# SADDLEHORN RANCH - FILING NO. 2

### PRE-DEVELOPMENT GRADING AND EROSION CONTROL PLANS

EPC STORMWATER REVIEW COMMENTS ARE SHOWN IN ORANGE BOXES WITH BLACK TEXT

PCD FILE NO. EGP221

**SADDLEHORN RANCH - FILING NO. 2**  
**GRADING & EROSION CONTROL NOTES & LEGEND**

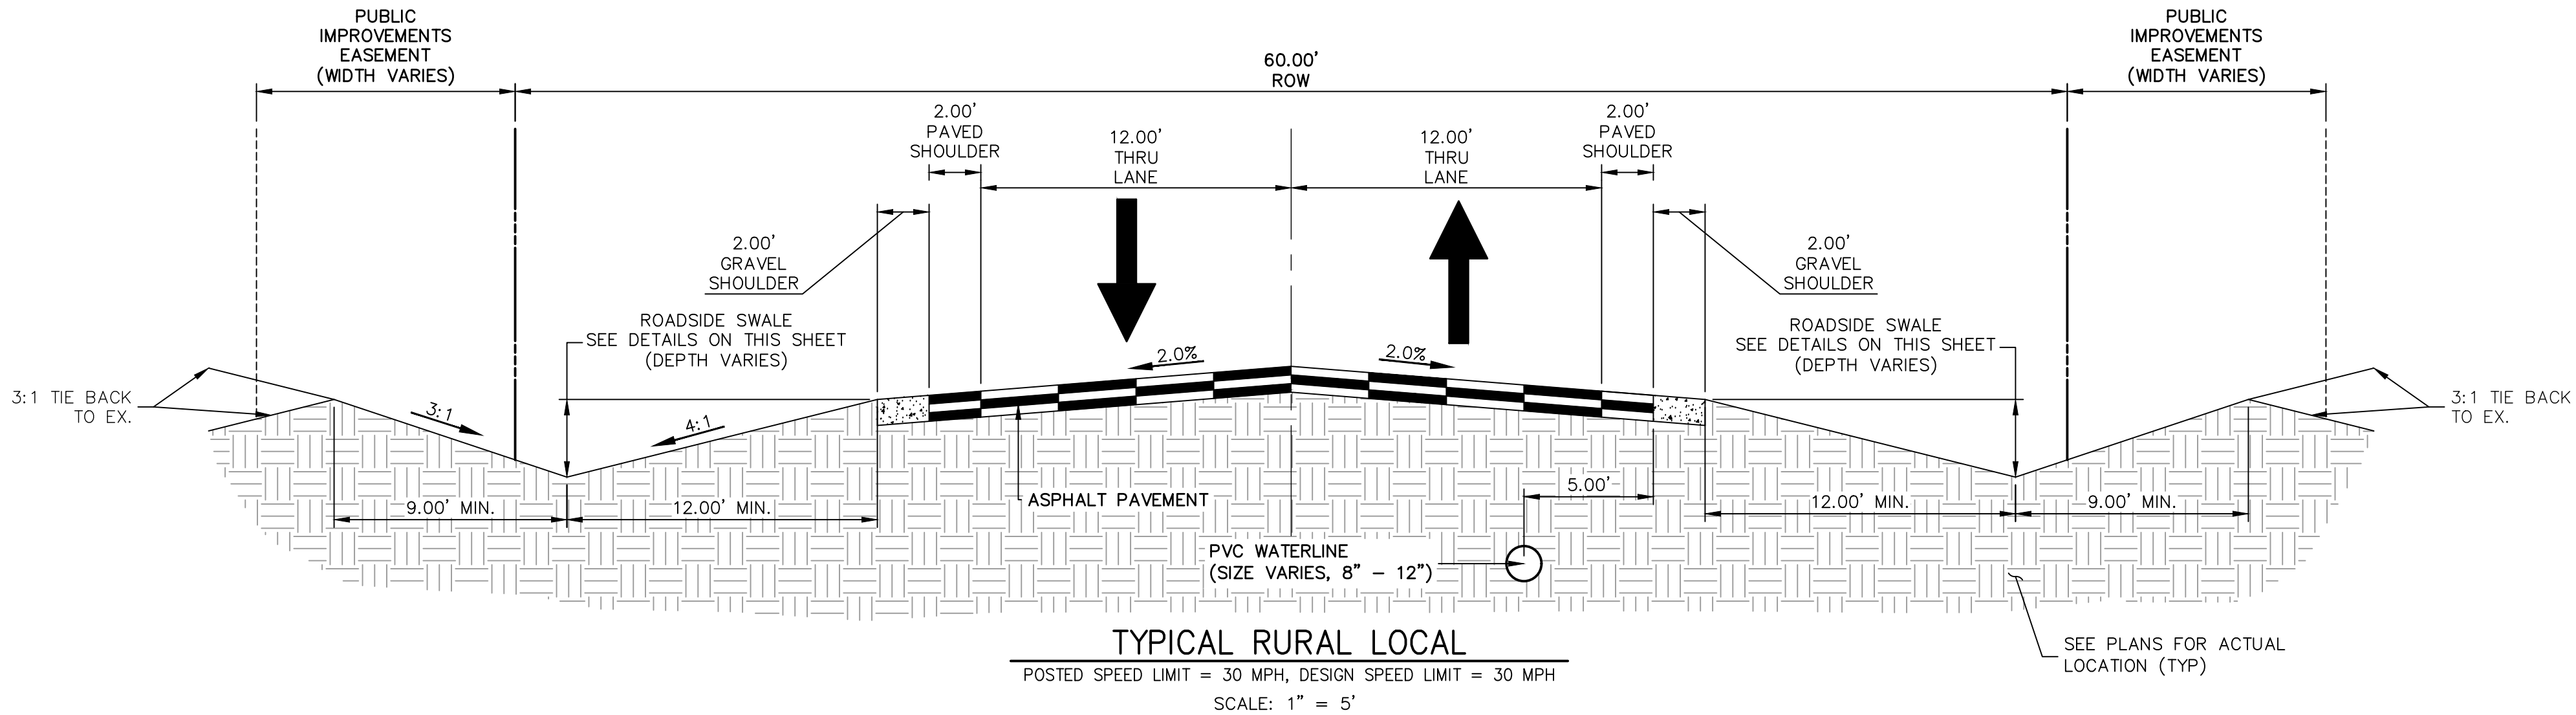
Upload a copy of the soils report.

Unresolved. Upload a copy on eDARP.

SADDLEHORN RANCH - FILING NO. 2  
COVER SHEET

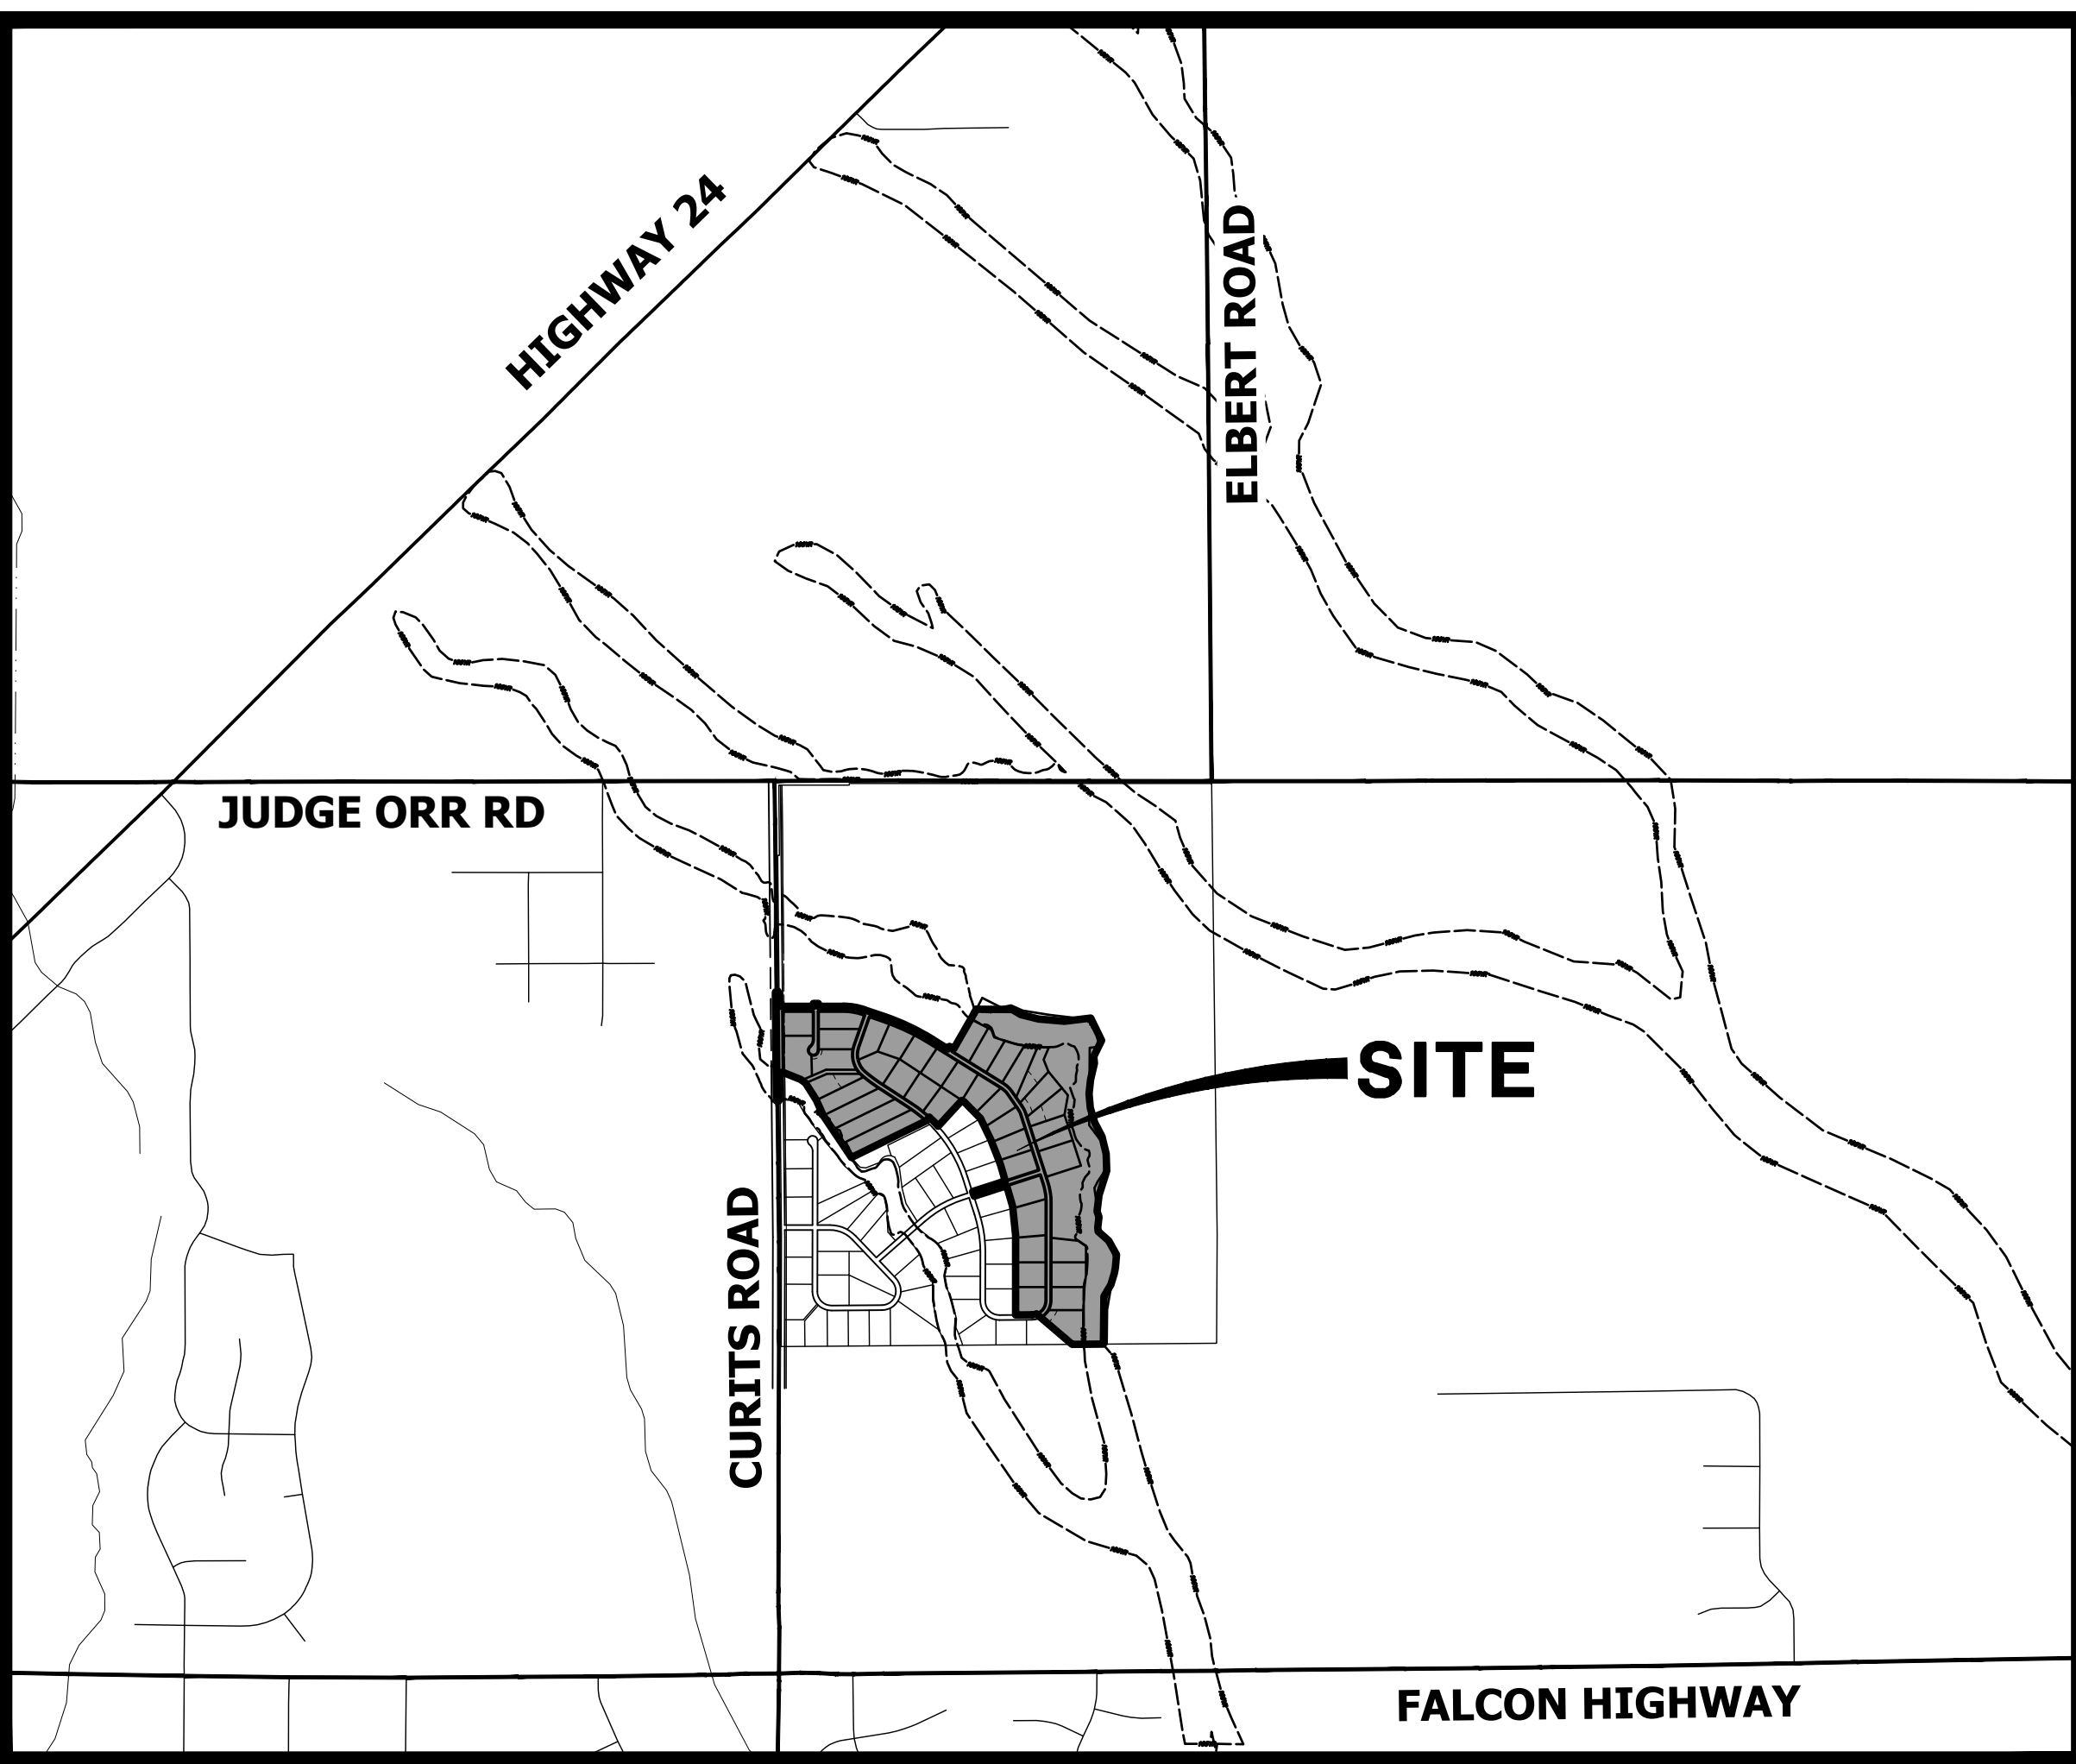
update the page numbers to match the actual number of pages submitted.
